Memo Report

Subject: Code Review; ICW Proposed Fire Alarm System Alterations at 1 City Center (8th Fl), Portland, ME

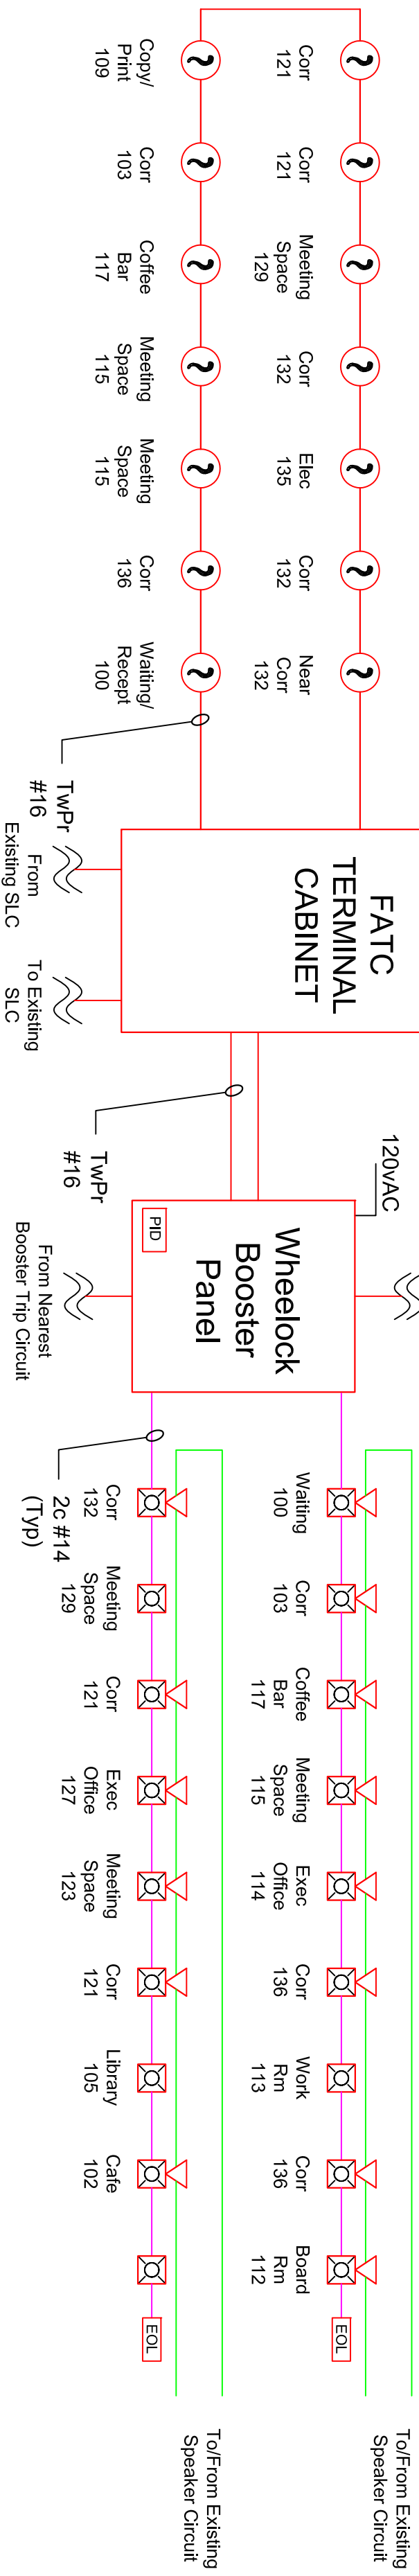
In general, the review indicates that the proposed modifications to the building’s fire alarm system will be code compliant. In fact, it appears that this proposed design will exceed the requirements of NFPA 72; as pertaining to the types and numbers of devices installed. Specifically, this design includes the installation of smoke detectors throughout all common areas within the office space; corridors, reception area, etc. As outlined above, it is assumed that this building is fully protected with an automatic fire sprinkler system. As such, it would be unnecessary to install smoke detection within these areas, along with the electrical closet. It is unknown if a smoke detector exists at the location where the terminal cabinet and power booster panel are located. The proposed design does not indicate that a smoke detector is installed, or will be, in this room. If a smoke detector is not currently provided, one must be installed above these panels to meet code requirements.

The proposed design also includes the installation of speaker/strobes within each of the two “executive” offices. Since these offices are primarily intended for only one occupant, along with the fact that speaker/strobes are indicated as being installed immediately outside each of these rooms and the sound level within these areas would likely be code-compliant without the need for devices inside the offices, these too could likely be deleted from the design; while still providing a code compliant system.

The battery calculations provided with the submittal documents only address the power requirements for the newly installed devices. It is assumed that the batteries indicated on the cut sheets provided would be

installed in the new power booster panel, but would likely only support the power to the strobes and not the speakers; which are typically powered directly from the main fire alarm panel/system. The calculations do not address if these additional devices (speakers) can be supported by the existing emergency power supply for the main fire alarm system.

1. Verify that a smoke detector exists at the location of the terminal cabinet and power booster panel. If not, add a detector at this location.
2. Verify the need for smoke detection throughout the new office area.
3. Verify the need for speaker/strobes in the executive offices.
4. Verify the ability of the emergency batter power system to support all additional speakers.
